**Re: Objection to Planning Application 2025/92799 – 26 Inglewood Avenue,
Huddersfield. HD2 2DS
(Cont'd)**

Please find below supplementary relevant images supporting our objection dated 17/11/25 against the above:-

1 : 50

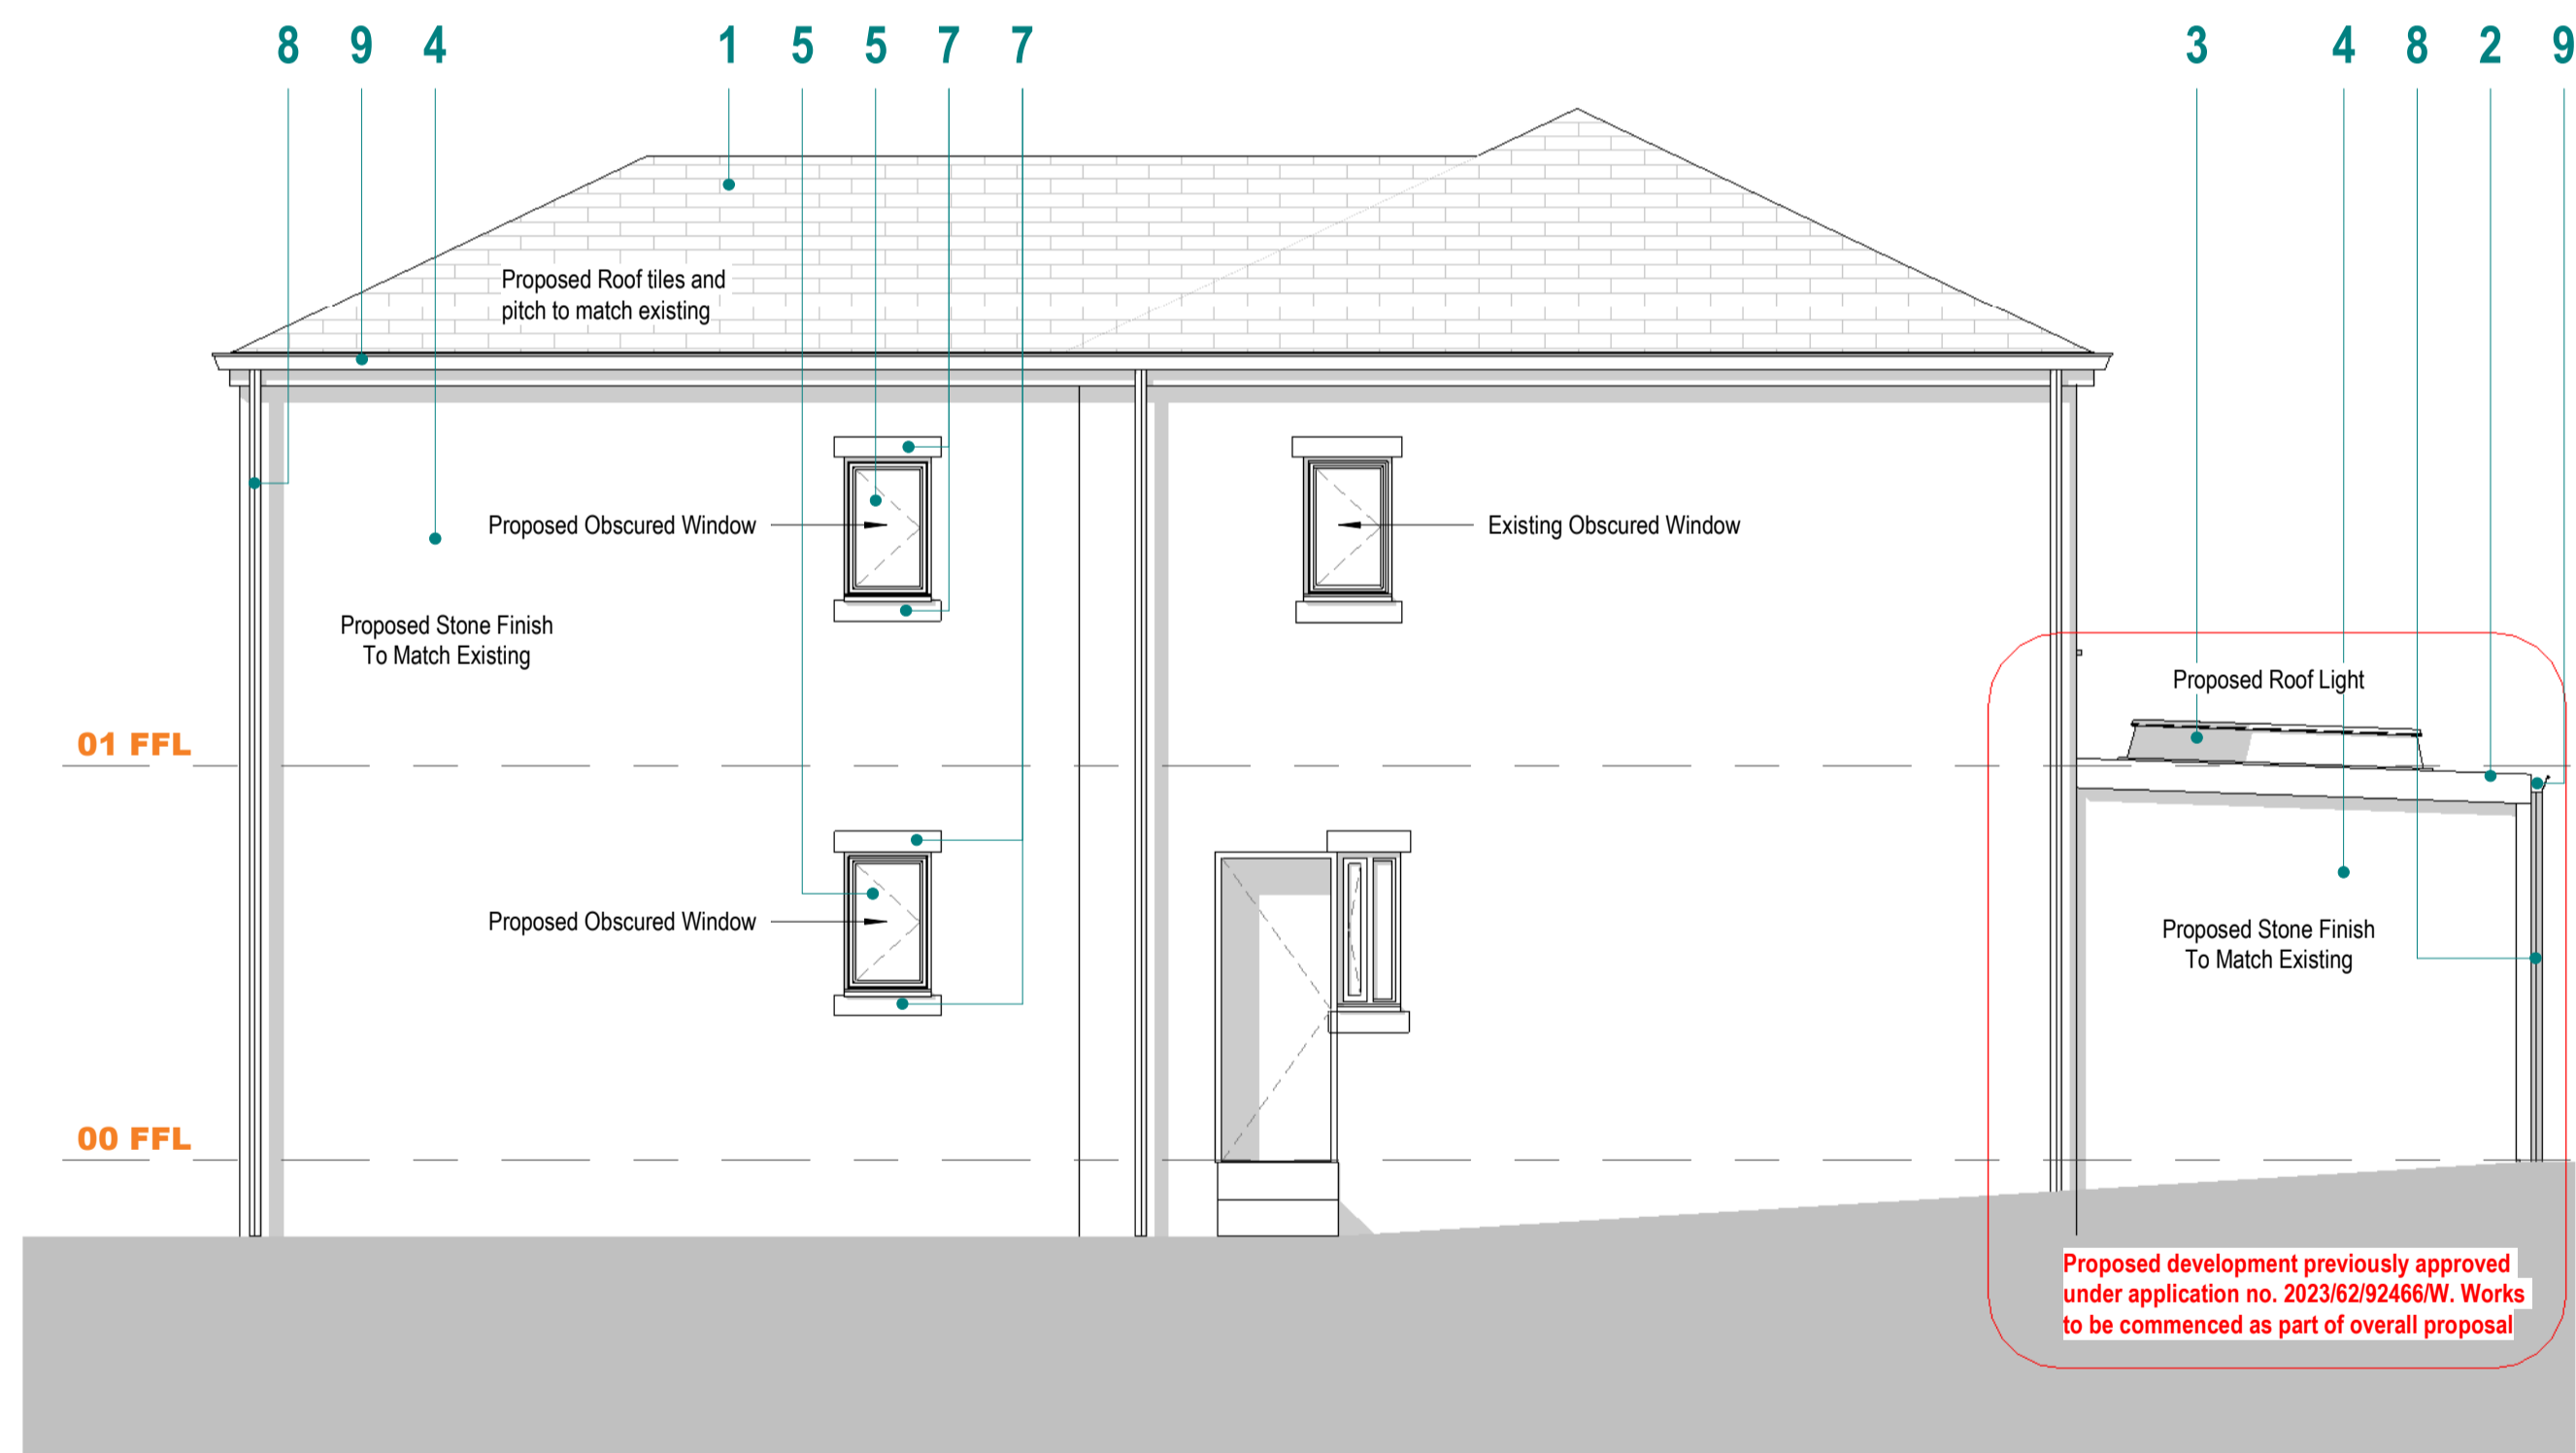
However, the proposed garage door alteration to a clear window and the extension also with a clear window will significantly reduce privacy.

Also they will overlook front garden, entrance path and driveway.

However, the natural light will totally be blocked off by the extension!

PROPOSED GROUND FLOOR
1 : 50

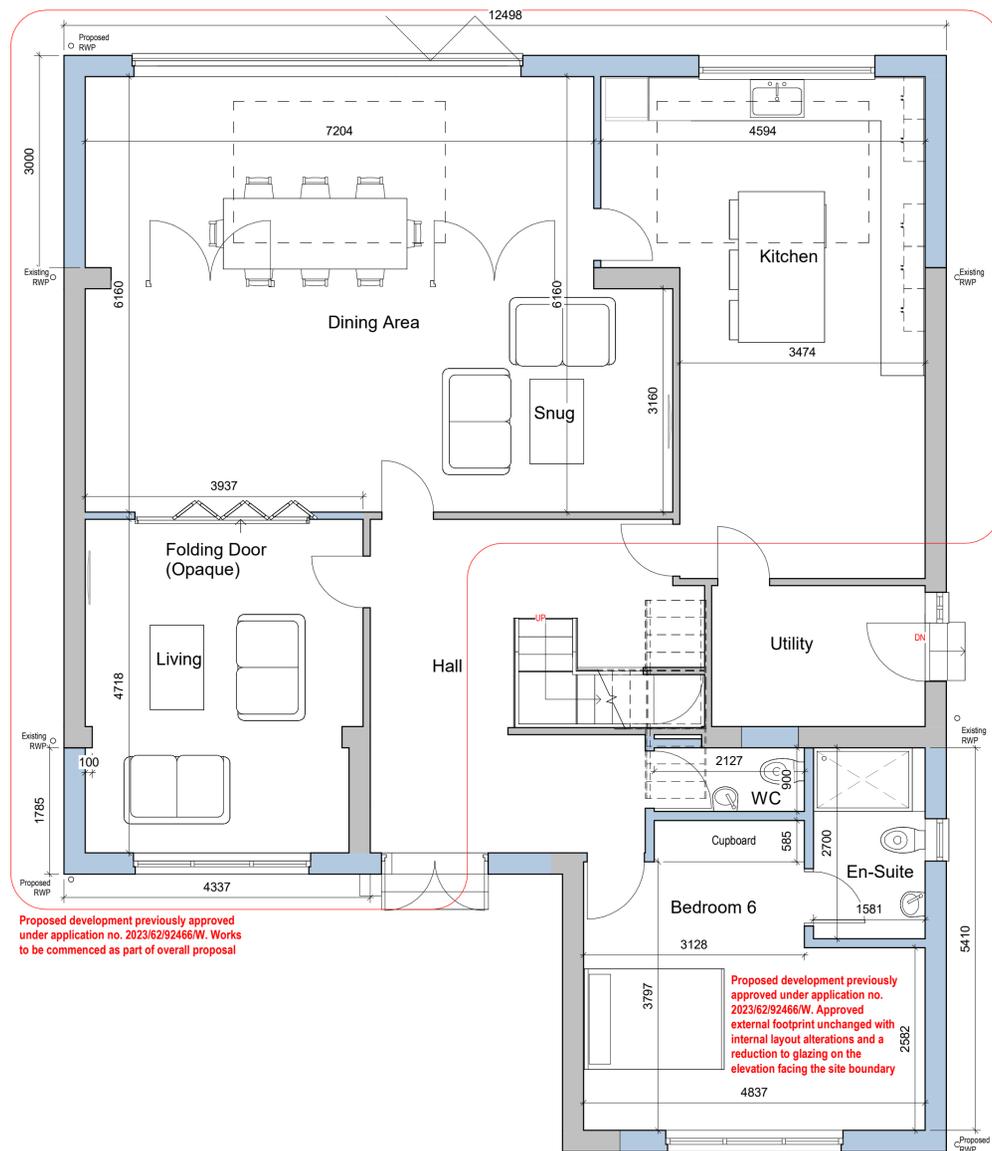
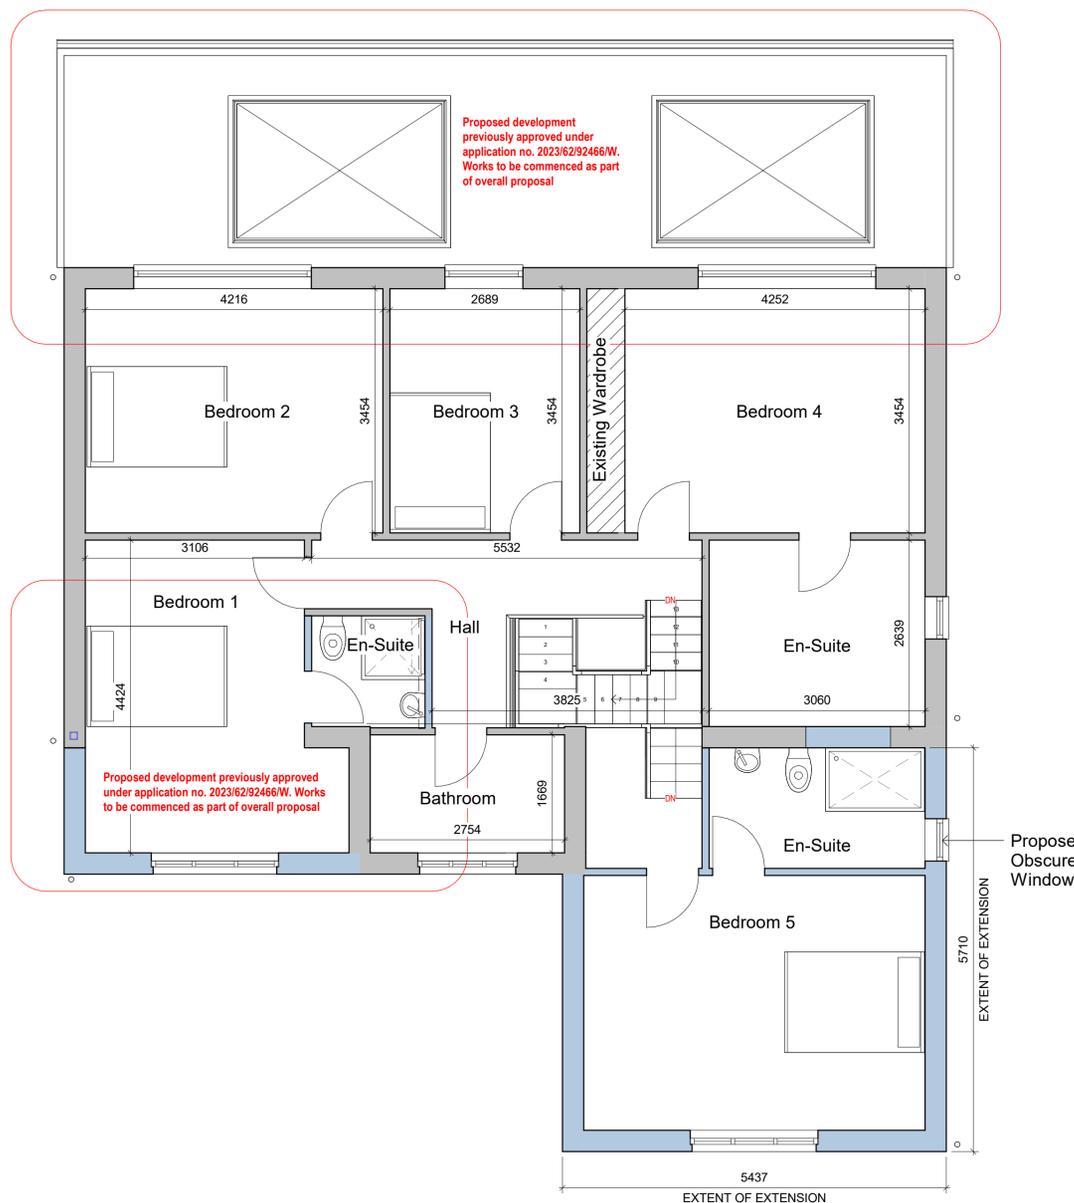
Image 10 shows how unique, uniform, tranquil and serene of the 'newer' Inglewood Avenue, no 24 & 19 (not in order) and beyond, built by Conroy & Booth, is. However, with the garage alteration this area will look odd without a garage. It will Cont'd...
